CITY OF ALBUQUERQUE

February 6, 2015

**RE: American Toyota – Temporary Lot (File: C18D012)
Conceptual Grading and Drainage Plan, Engineer's Stamp Date 1-9-15**

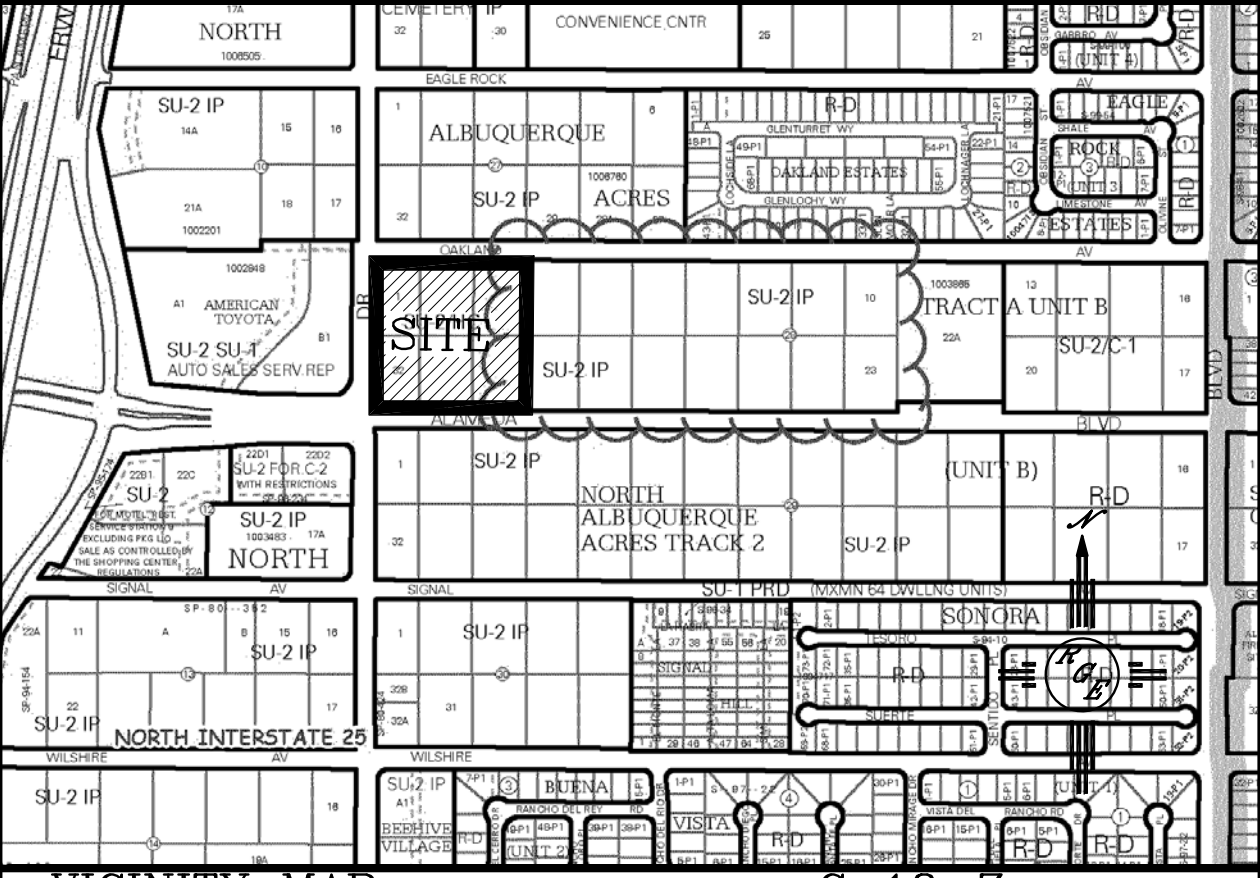
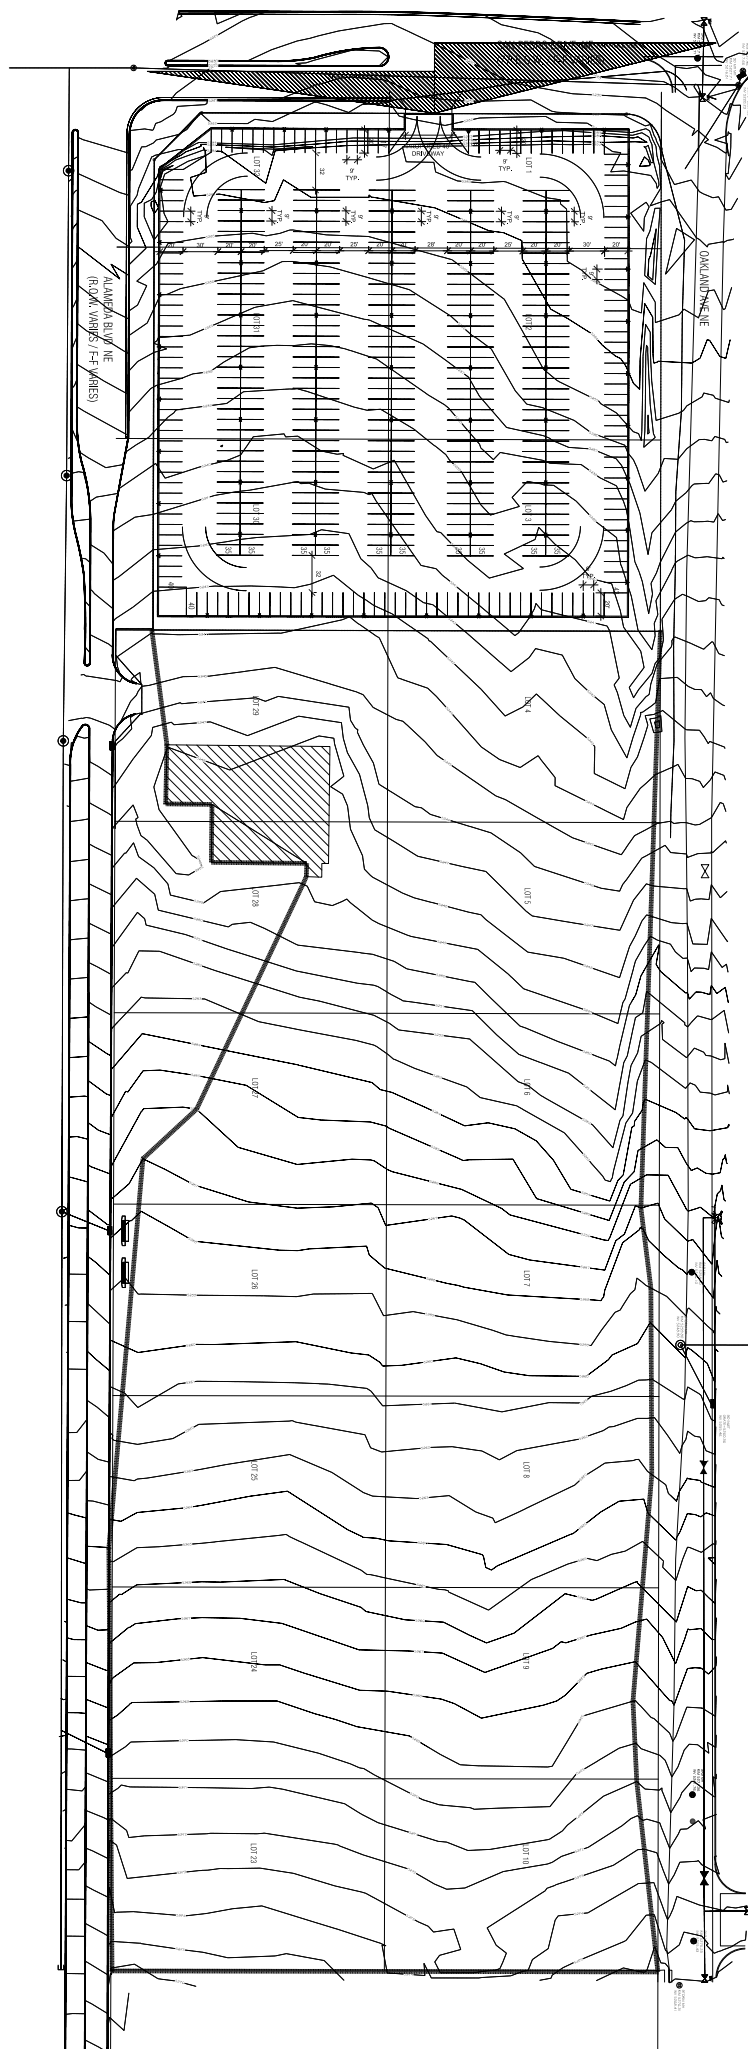
2. The upland flows are 38.4 cfs based on a fully developed condition, and based on 9.72 Acres. However, Eagle Crest Subdivision is a 12.4 Acres subdivision and is not intended to drain across this lot in the fully developed condition (C18D064B). Therefore offsite drainage should be based on existing land treatments, and 12.4 Acres.

3. Basin A1 land treatments should be modified such that half the Treatment C is a Treatment D. The reason for the increase is that rows of vehicles will cause concentrated flows along the edge of the parking rows and to account for such, half the treatment C area should be treated as a D.

4. With the increase in land treatments, some ponding may be required to maintain the allowable discharge.
5. Lot appears to be 2 basins, with the south side flowing into a pond and then through a 12' CMP at 0.0 %. Show pipe has capacity. Pipe should have a minimum slope.

6. Sump inlet calculations should show how the area is calculated. As we discussed, it would be helpful to have a full spreadsheet, similar to the street capacity calculations, that can be copied and used for similar type inlets. If the grate gets clogged how will emergency overflow be handled.

7. Can the Storm Drain in Oakland and San Pedro support the proposed flows per the design assumptions? What were they designed for?
